PCDD File No. PPR-21-036, VR-22-_____

Revised February 9, 2022

Re: NORTHCREST CENTER NO. 1A
Northwest corner of Canada Drive at Constitution Avenue
Lots 3, 4 and 5, NORTHCREST CENTER
El Paso County, Colorado 80922

NORTHCREST CENTER NO. 1A FINAL PLAT

**NORTHCREST CENTER NO. 1A**  
**FINAL PLAT**

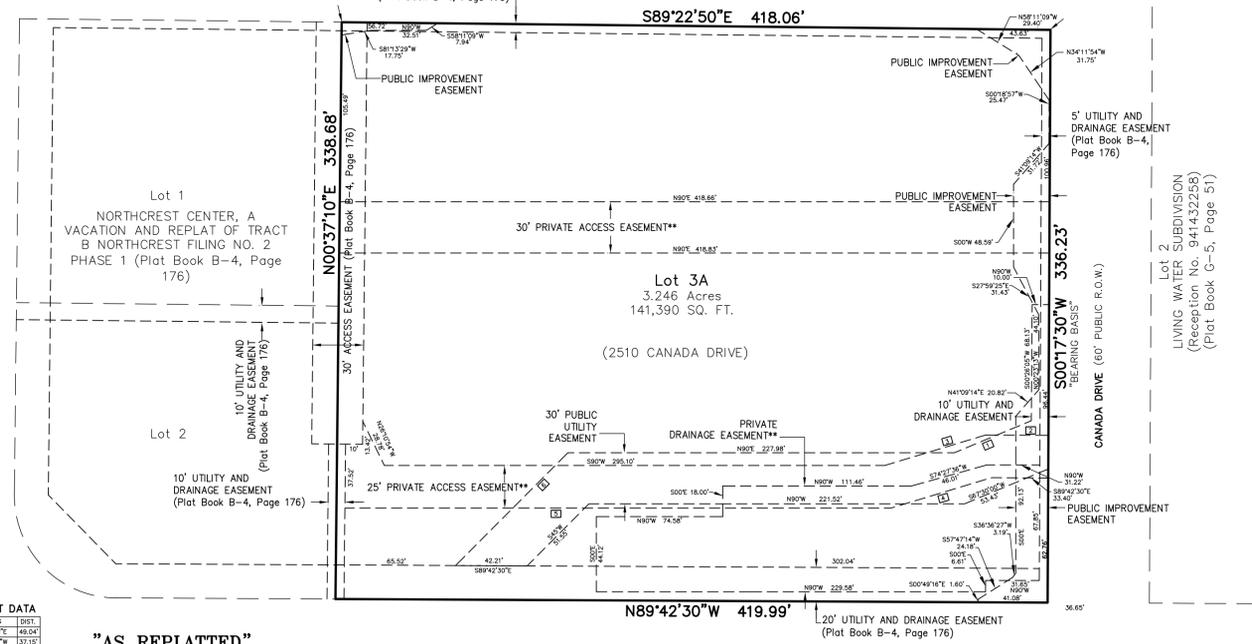
PLEASE CORRECT BASIN AND FEE STATEMENTS. THIS IS NOT THE CORRECT BASIN. THE CORRECT BASIN IS SAND CREEK. FEES ALSO DO NOT MATCH DRAINAGE REPORT PG 13. A REVIEW OF NORTHCREST FILING 2 AND NORTHCREST FILING 2 PHASE 1 HISTORICAL FILES AND FILE #SF85007 PROVIDES INFORMATION ON FEES AND IMPROVEMENTS. PLEASE SEE COMMENTS IN DRAINAGE REPORT.

Include roadway classification and if ROW is public

Must be renamed Lot 3A per LDC Section 7.2.5(C)

Show 15ft easement around the entire detention pond
